Please upload onto Ocella the email below which is the revised consultation response from **ADC Drainage Engineers** to discharge of condition application **BE/21/20/DOC** – Salt Box.

Engineers comments in respect to surface water drainage;

APPLICATION NO: BE/21/20/DOC

Site Address: Land At Salt Box West Of Shripney Road Bognor Regis PO22 9NW

SECTION 1-1
CROSS SECTION THROUGH AT-401
SCALE 1:25
(REFER TO C-7010 FOR LOCATION)

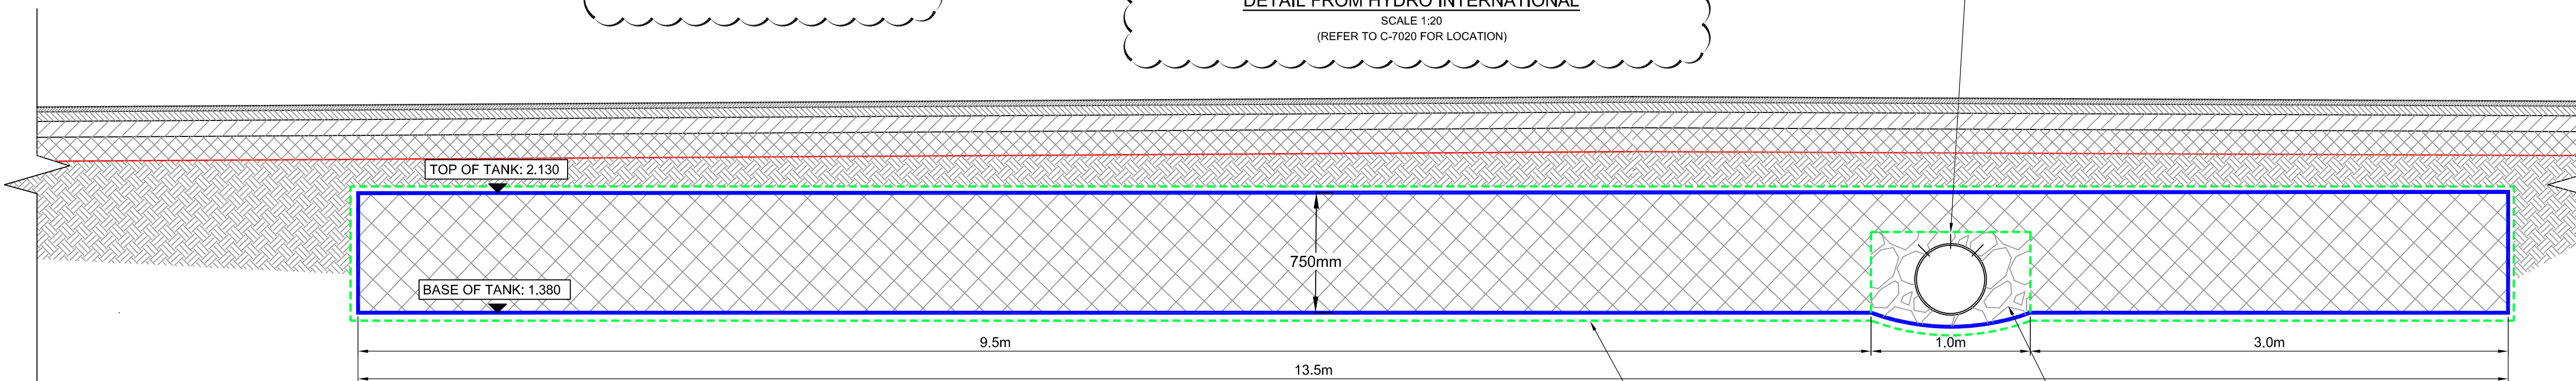
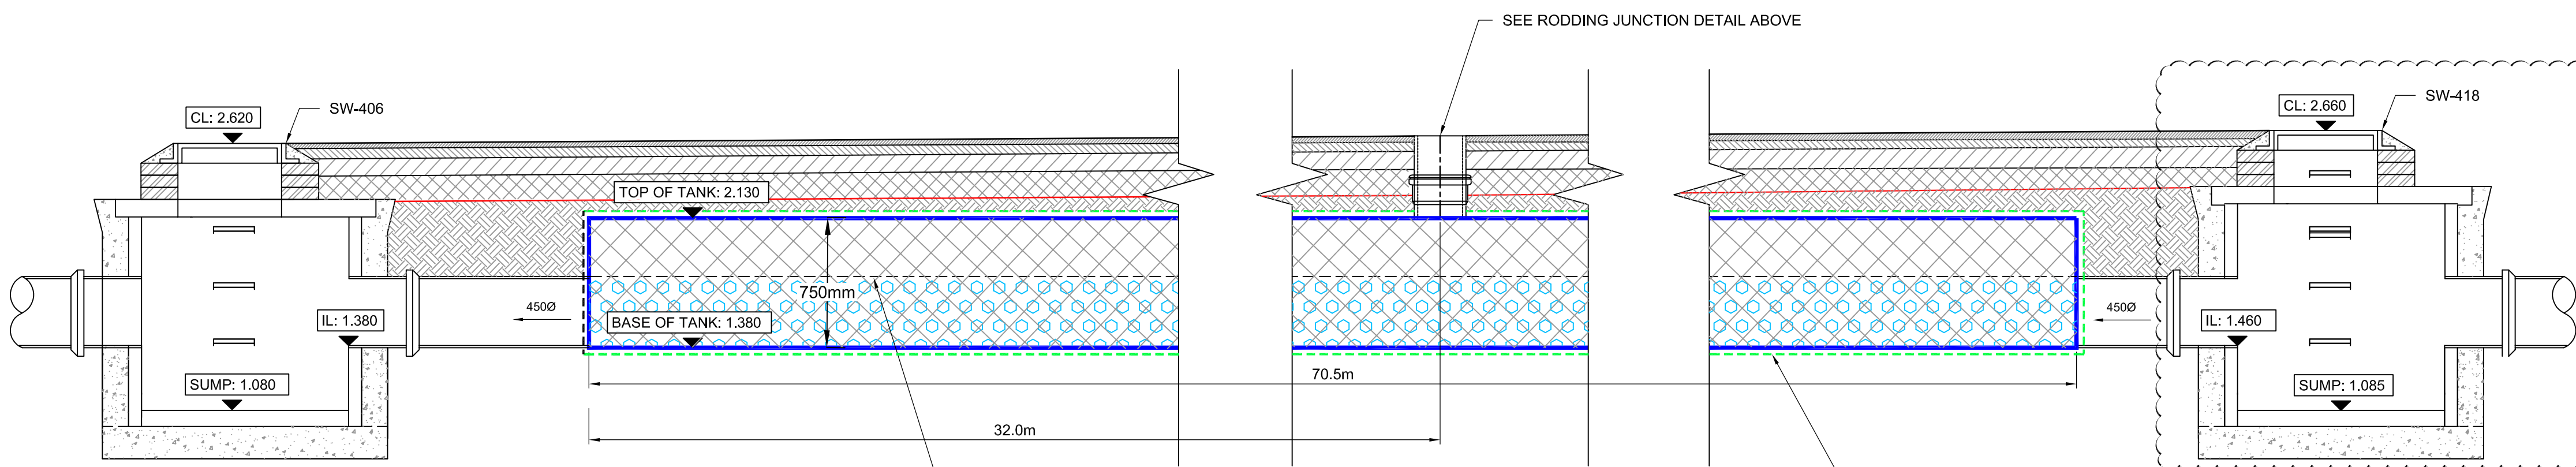
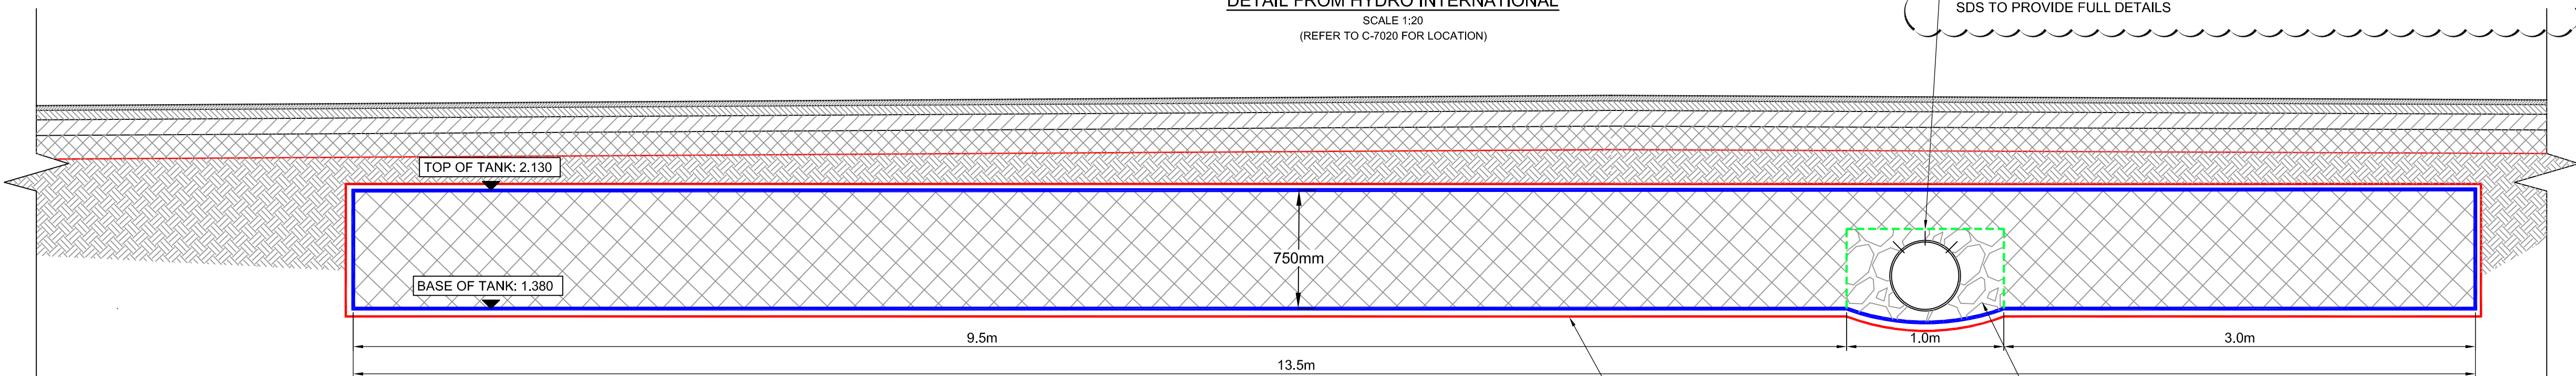
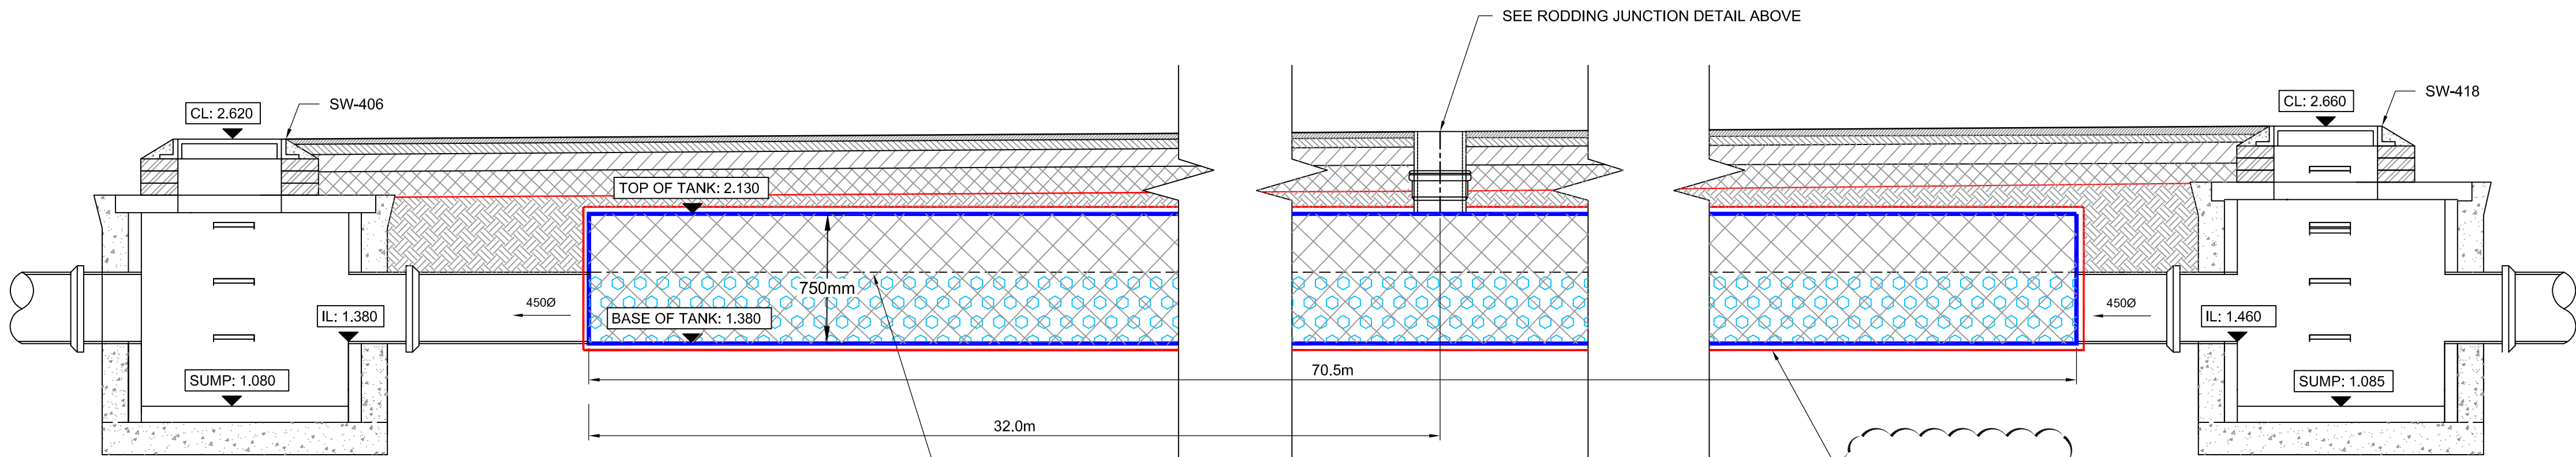
15. Drawing 7010 - SW-405 to tank – specify pipe diameter and a reasonable gradient.
Gradient added ok
16. Drawing 7103 (Phase 2)– Section 2-2 – should this be labelled AT-401?
401 label added. ok

17. Drawings 7103 (Phase 1 & 2) ie. AT-201 and AT-401 – specify granular surround to pipe including thickness. Provide permeable geotextile wrapping to bedding.
Granular material detail note added and permeable textile wrapping note added. Done for AT-401. AT-201 – no drawing supplied? Added to AT-201. Ok but I note that at some point the geotextile surrounding all crated tanks has changed from impermeable to permeable. Please change back to impermeable to prevent groundwater intrusion. Only the geotextile surround to the perforated pipes should be permeable. Noted, tank membranes updated as requested.

18. AT-401 – Provide integral catchpit manhole in crates at connecting junction as opposed to a 300mm vertical pipe.
SDS tanks do not have a tank spec that allows for manholes to be installed within the tank but can provide a rodding access similar to what is shown and they allow for junctions in the pipe. ok but T junction access detail needs to refer to AT-401. Note added. ok

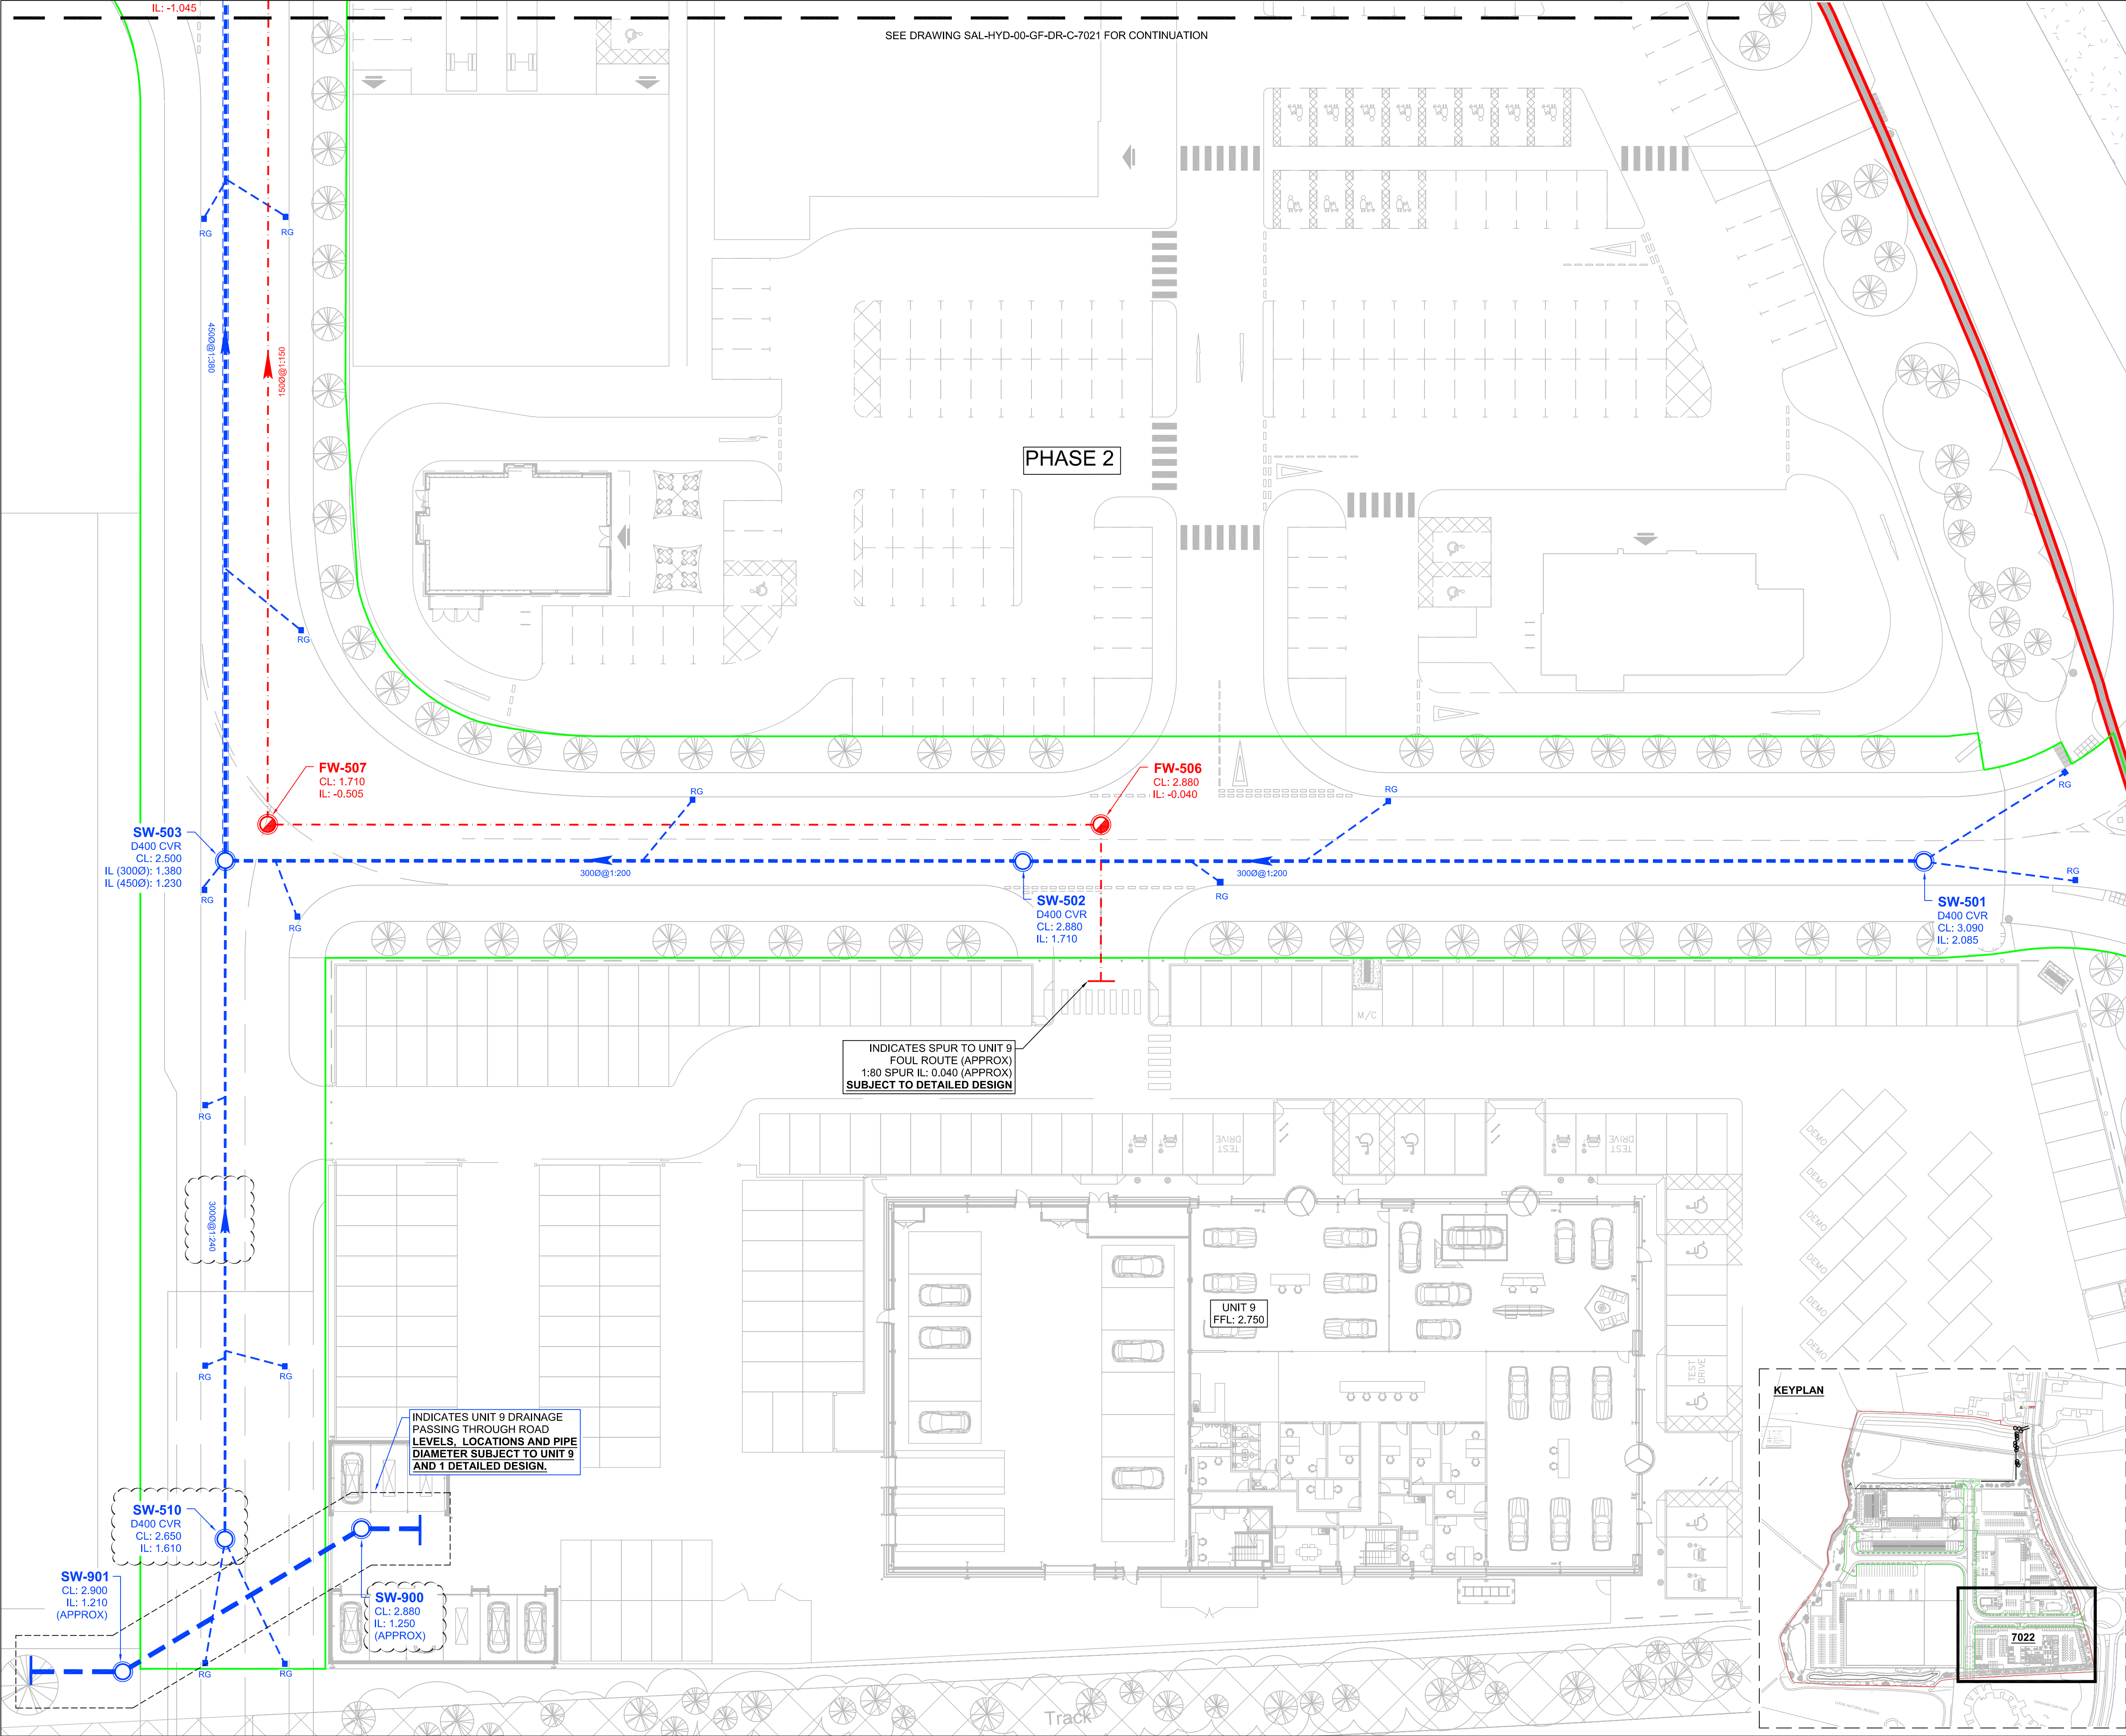
7. Manhole SW-900 invert level is different on plans 7011 and 7022. Noted.

PH1-7022 IL revised to suit PH2-7011. ok
